**RE: The Lofts at Winrock  
7500 Indian School NE  
Grading & Drainage Plan  
Engineer's Stamp Date: 3/6/25  
Hydrology File: J19D089  
Case # HYDR-2025-00112**

Based upon the information provided in your submittal received 4/2/2025, the Grading & Drainage Plan **is not** approved for Building Permit and Grading Permit. The following comments need to be addressed for approval of the above referenced project:

CITY WORK ORDER

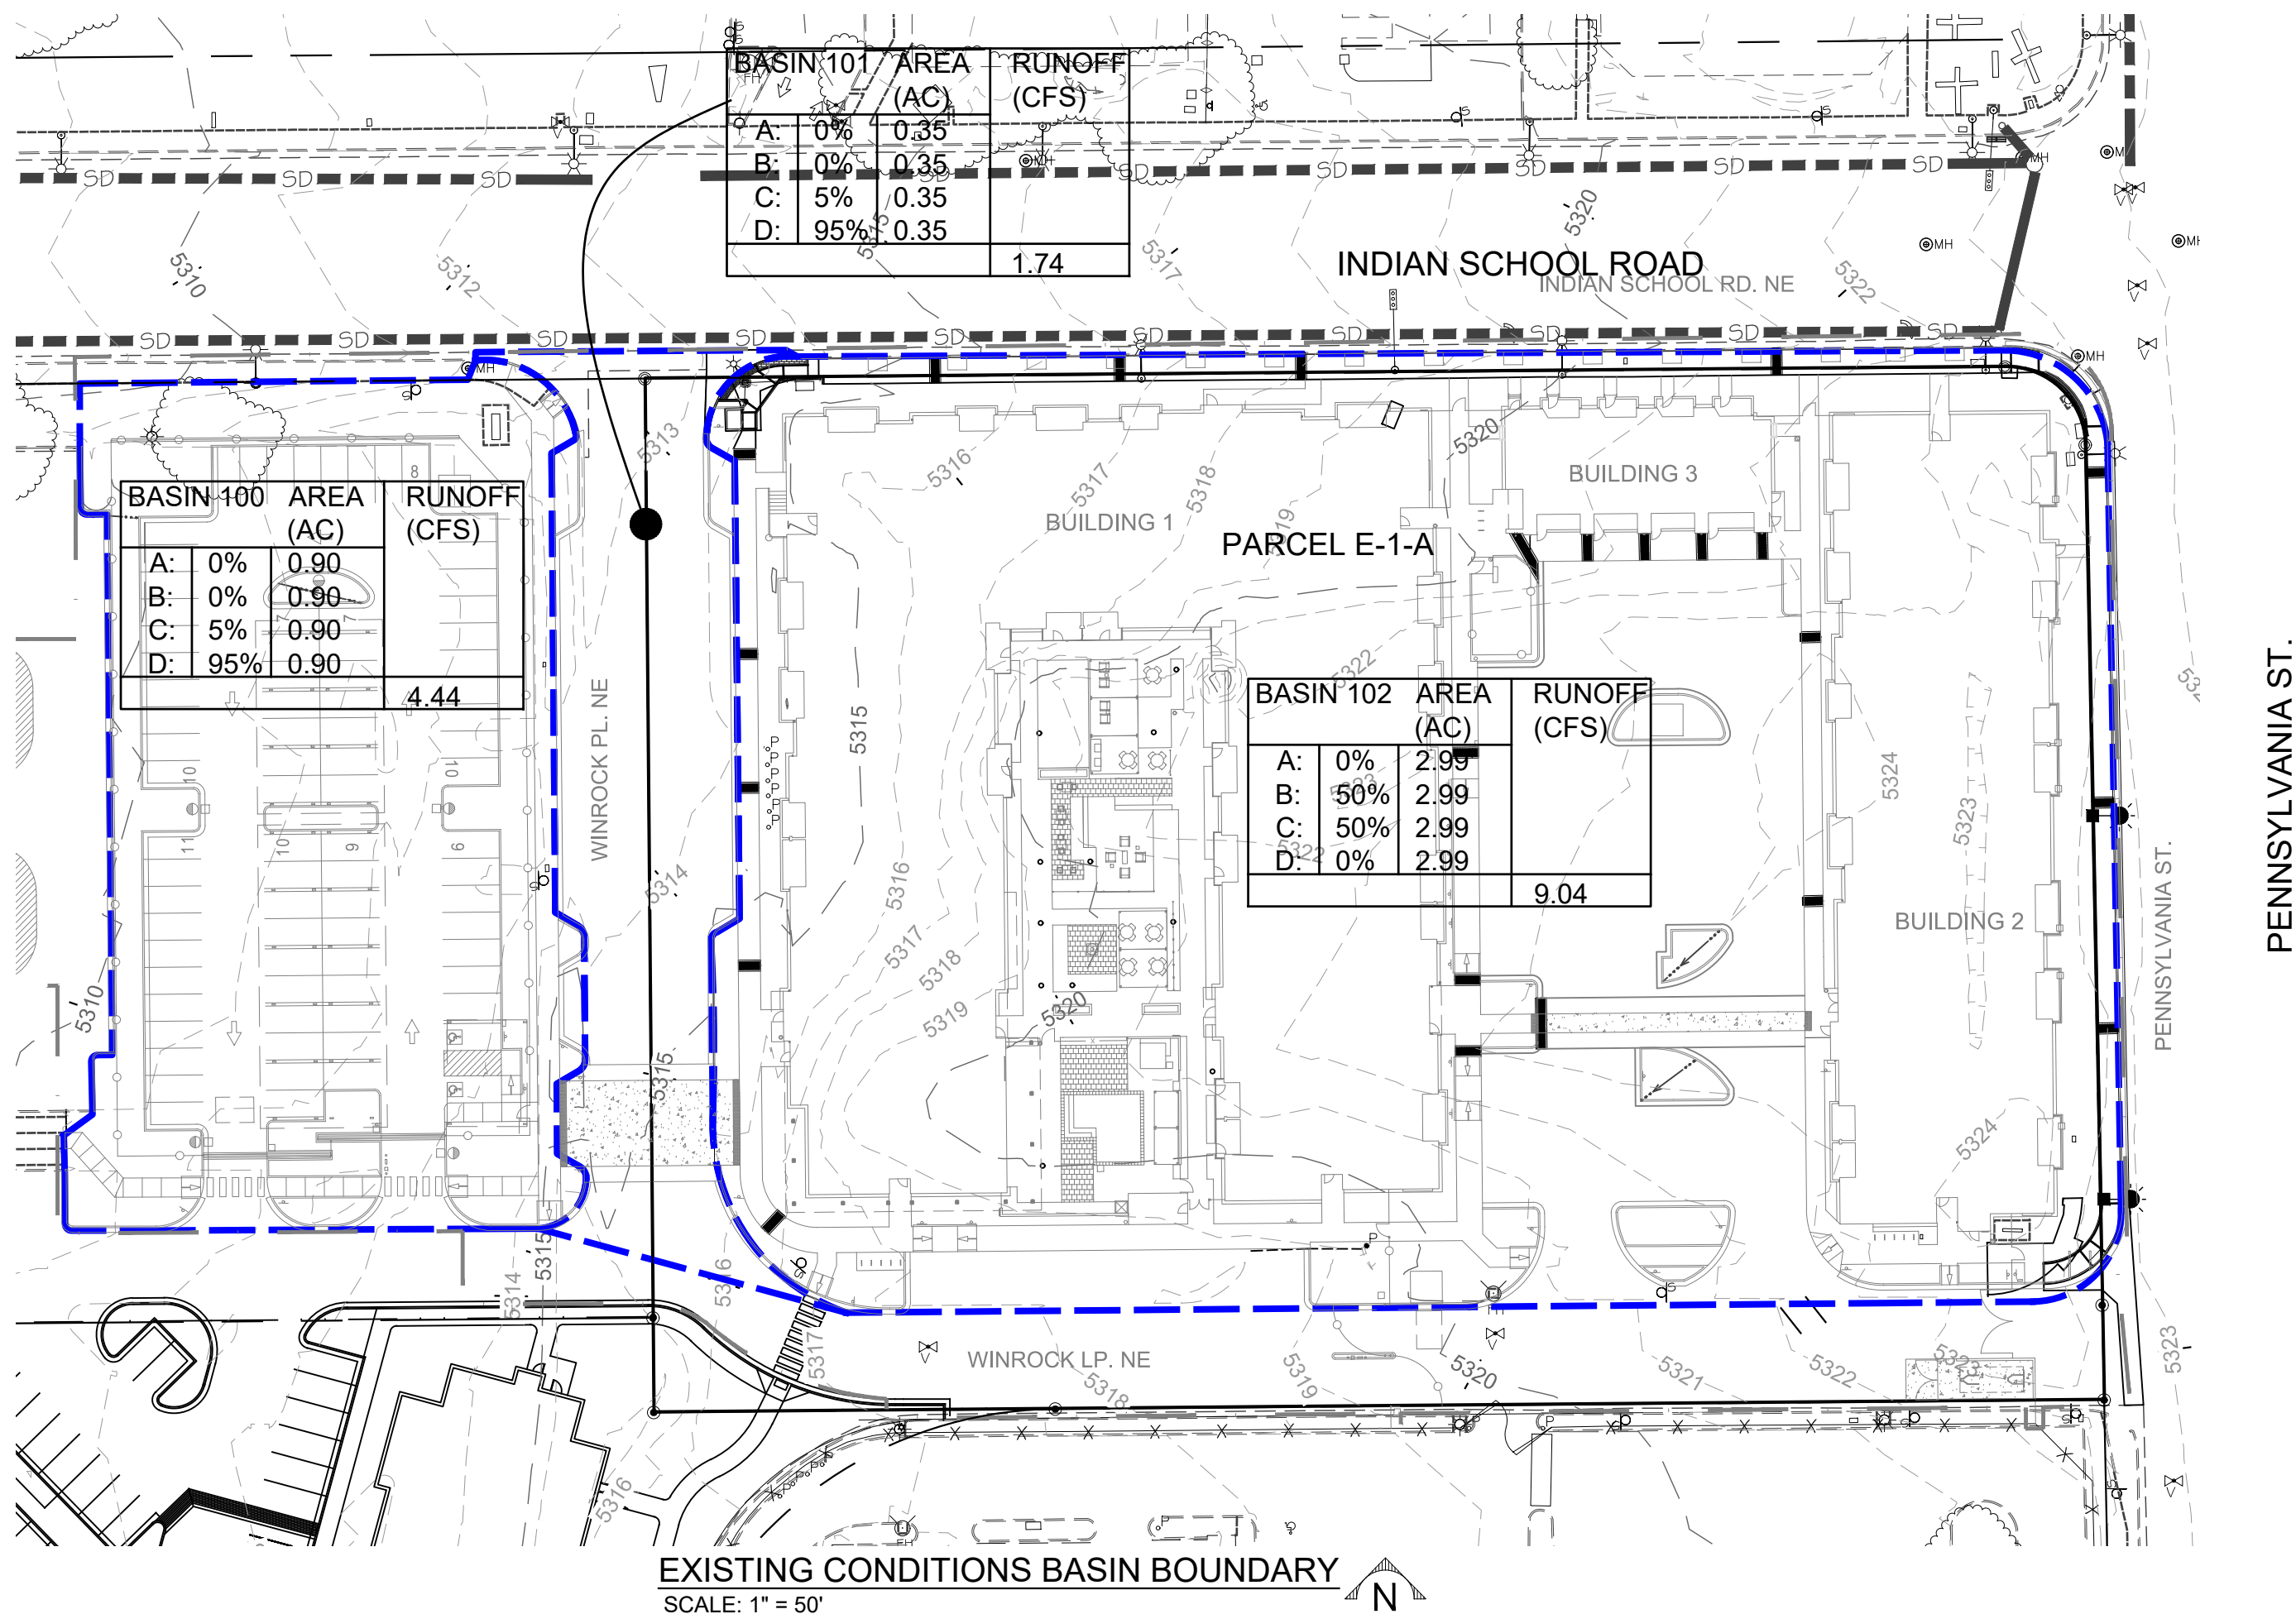
1. Payment in Lieu (Amount =  $1,243\text{CF} \times \$8/\text{CF} = \$9,944$ , per Drainage Plan sheet 1 of 17) of onsite management of the SWQV must be made. Please submit a Waiver Request form to Hydrology for approval.

GRADING PLAN

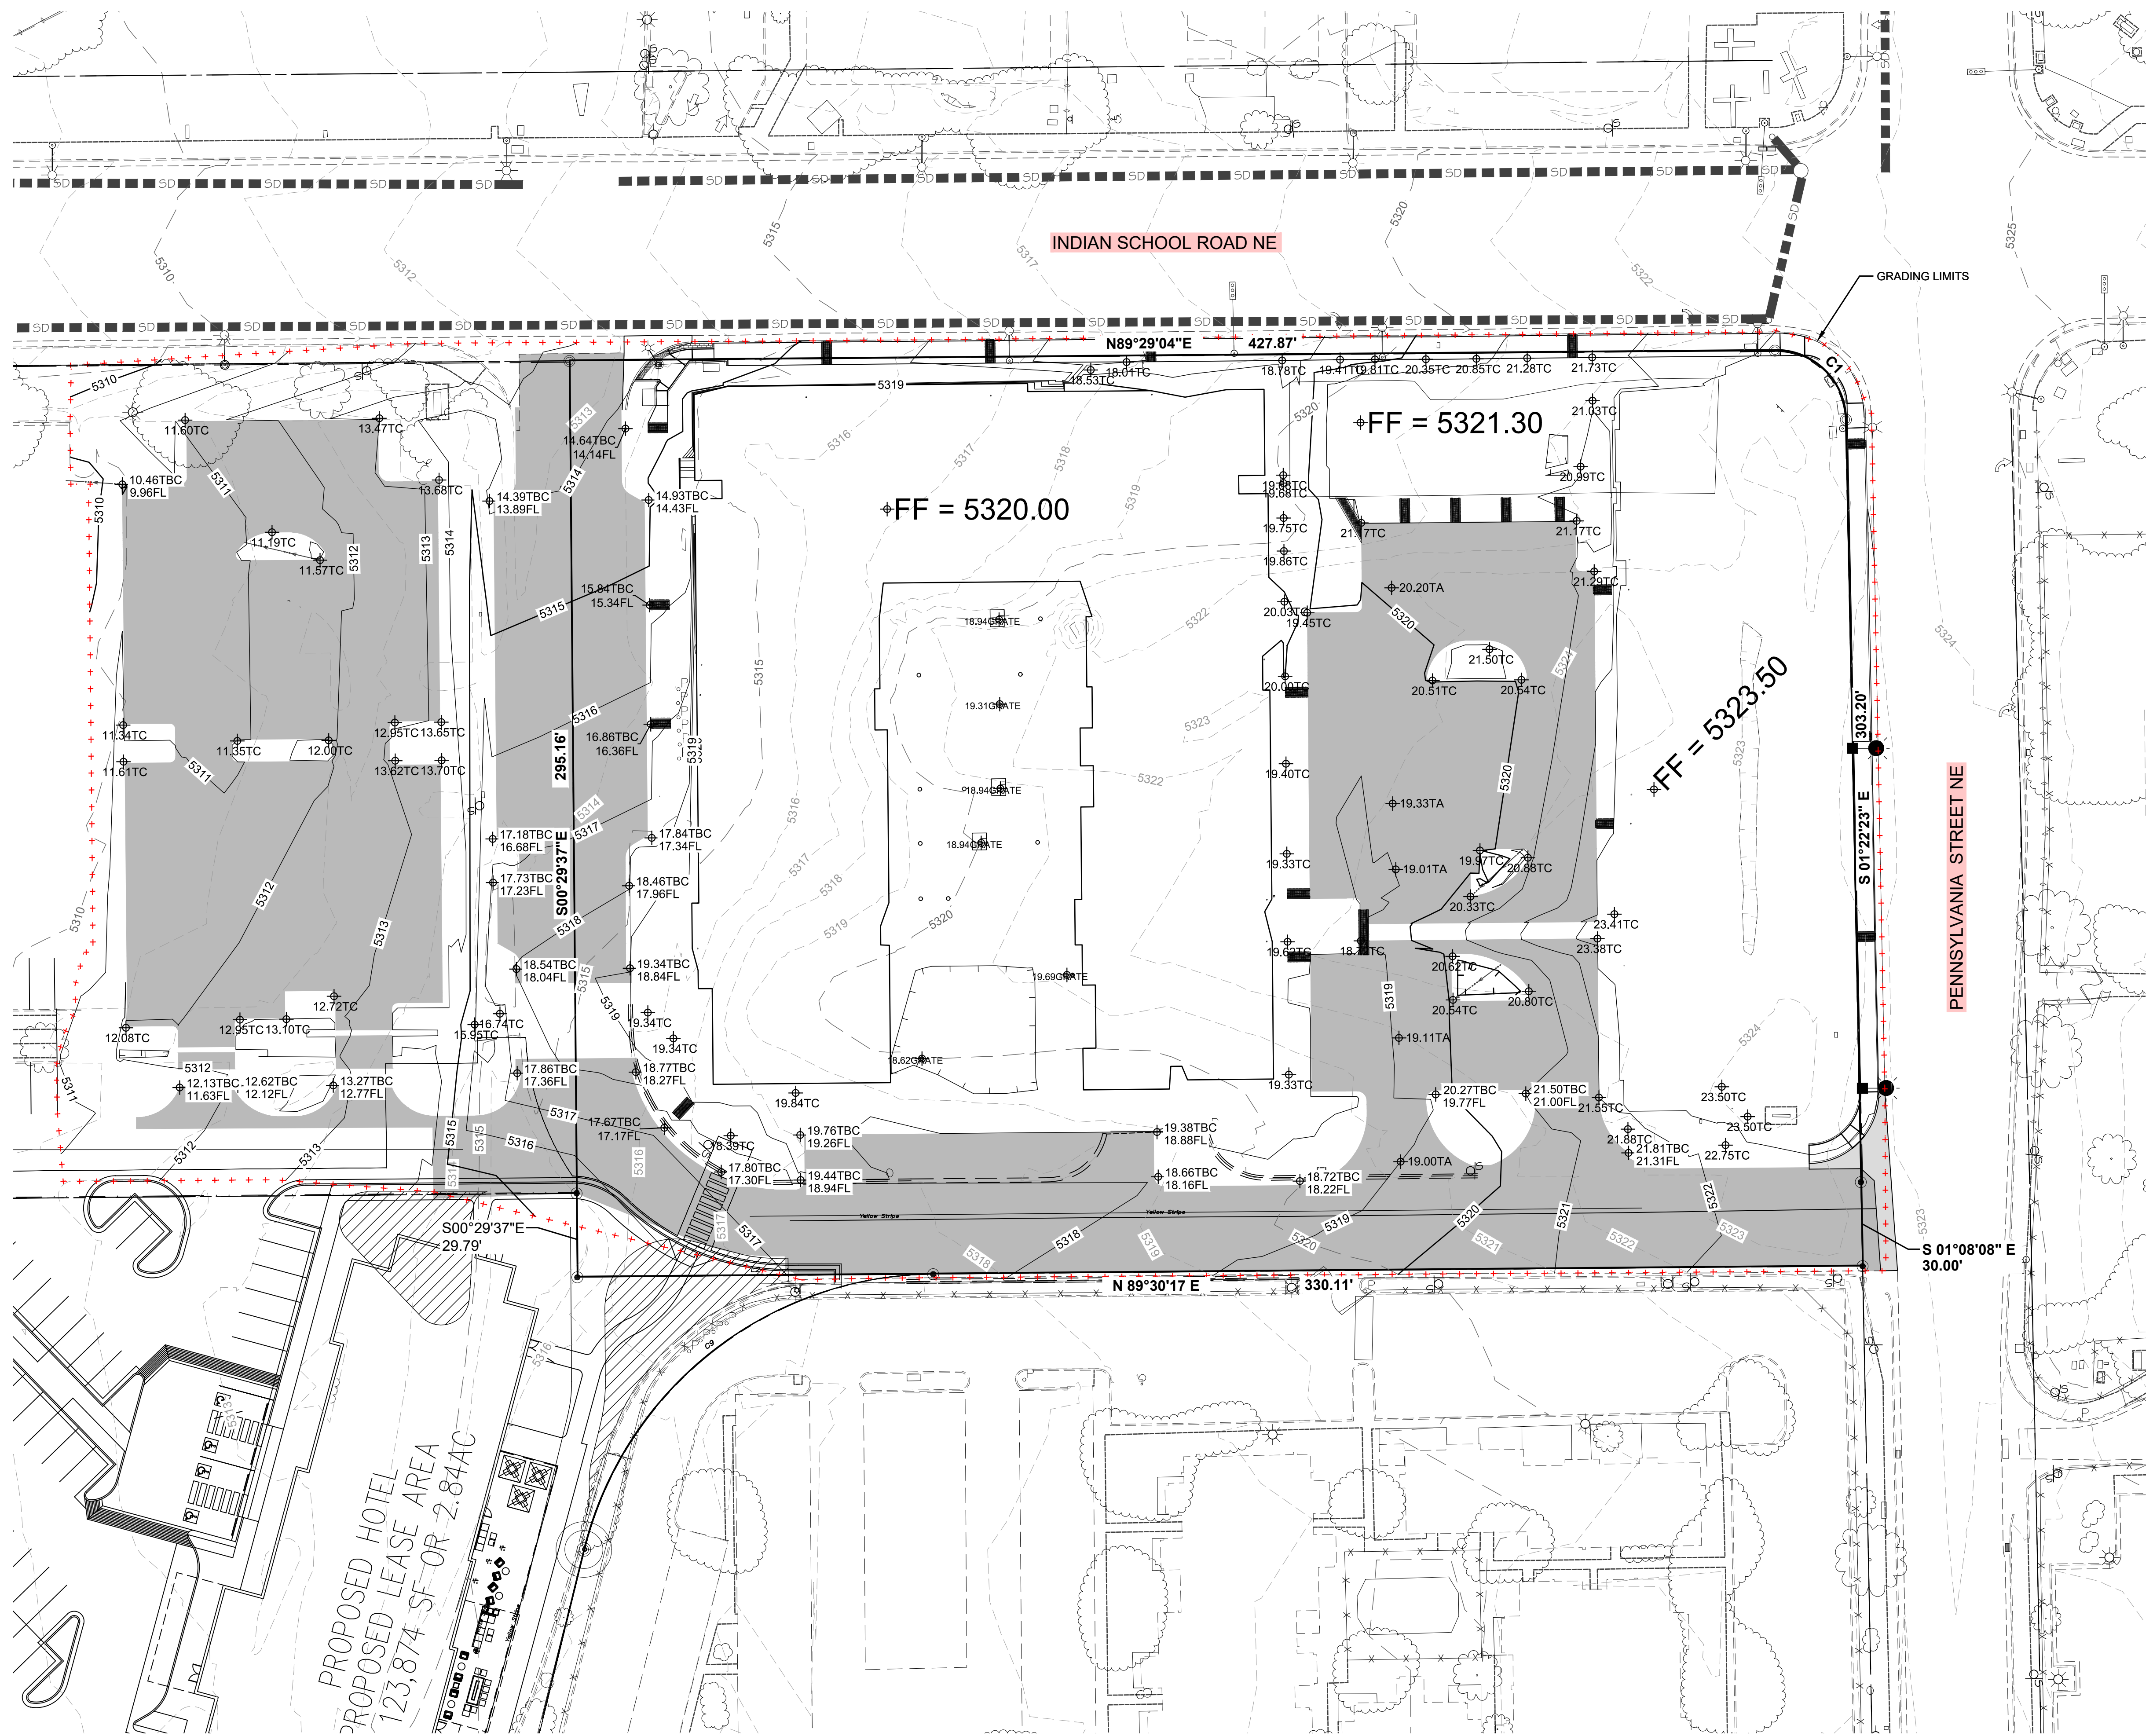
2. An SO-19 Permit will be required and should be included on the request. Please include the [standard SO-19](#) notes on the grading plan.
